# SPECIAL USE - 9910 TOMAHAWK TRAIL

LOT 9, BLOCK 1 INDIAN WELLS - FILING 1

SPECIAL USE SITE PLAN  
LOT 9, INDIAN WELLS FIL 1

SP1

# SPECIAL USE - 9910 TOMAHAWK TRAIL

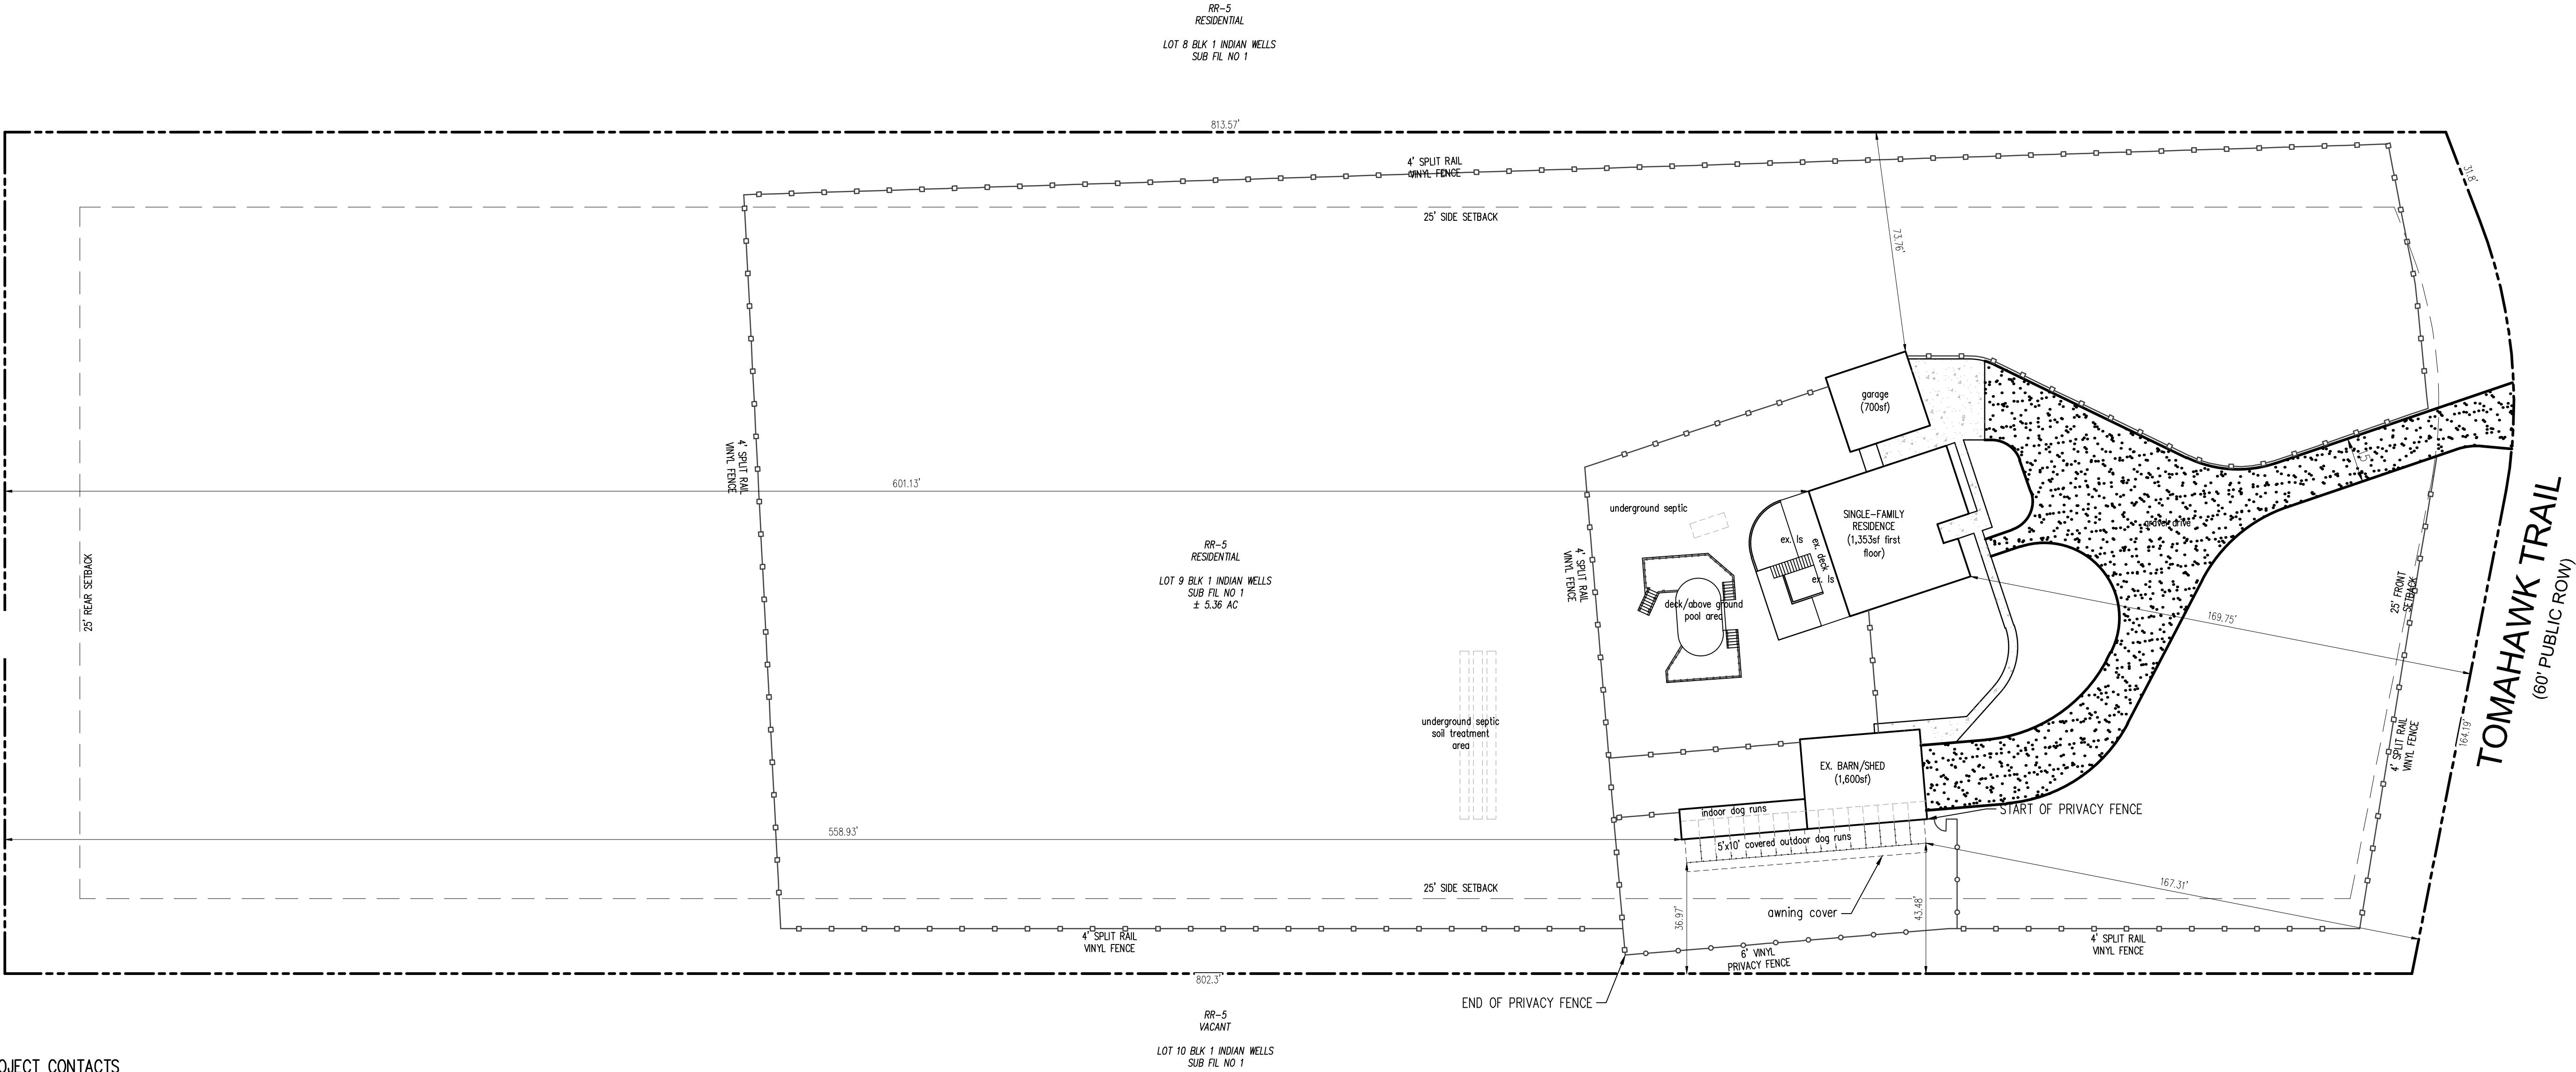
Please include:  
-landscaping coverage (%)  
-impermeable surface coverage(%)

include items from the kennel to lot coverage

Please include:  
-location and dimensions of:  
.ROW  
.easements  
.property lines  
-any outdoor lighting: include: height and illumination specs, if none, then specify  
-location and dimensions of utility lines or associated infrastructure

Please depict dimensions for these structures and include them to the lot coverage %

Include traffic circulation to and from residence and kennels

Add missing structure  
RESPONSE: ADDED

label structure  
RESPONSE: LABELED

Add 60ft Row  
RESPONSE: ADDED

Is this fencing? if so, please include the height

Please depict all setback distances from any kennel structures to all property lines

Please add legend for line types

These appear to be outdoor dog run areas  
Please label all kennel use areas to clarify use.

Please depict ways to mitigate noise, smell, or visual factors due to the kennel items begin less than 200 ft from property lines

Setback of the kennel area would appear be the outermost kennel run areas not the inner most cages. The setback of the kennel areas appear to much closer to the property line

RESPONSE: BUILDINGS ARE ONLY IMPERVIOUS COVER. REMAINING AREAS ARE NATIVE OR EXISTING LANDSCAPE AREAS.

RESPONSE: PREVIOUSLY INCLUDED. ADDITIONAL SF LABELS ADDED TO PLAN

RESPONSE: ALL EASEMENTS, ROW AND PROPERTIES LINES PREVIOUSLY SHOWN. THIS IS A RESIDENTIAL APPLICATION AND NO LIGHTING IS PROPOSED

RESPONSE: SF AREAS ADDED TO PLANS AND PREVIOUSLY INCLUDED IN TOTAL BLDG COVERAGE/AREA

RESPONSE: THIS IS A RESIDENTIAL APPLICATION NO ADDITIONAL CIRCULATION OUTSIDE OF DRIVEWAY ACCESS IS PROPOSED. DRIVE WIDTH ADDED.

RESPONSE: SETBACKS ARE SHOWN FROM DOG RUNS. OUTDOOR FENCED AREA IS PART OF THE RESIDENTIAL BACK YARD

RESPONSE: ADDITIONAL LABELS PROVIDED

RESPONSE: ADDED

RESPONSE: THIS IS A PORTION OF BACKYARD THAT IS FENCED AND NOT A PART OF THE FENCED RUNS

RESPONSE: A 6' PRIVACY FENCE IS PROVIDED AND WILL BE EXTEND THE LENGTH OF THE SOUTH BOUNDARY FOR THE BACKYARD. ADDITIONAL LANDSCAPING WILL BE PROVIDED FOR ADDITIONALLY SCREENING. DOG WASTE IS PICKED UP DAILY AND PROPERLY DISPOSE.
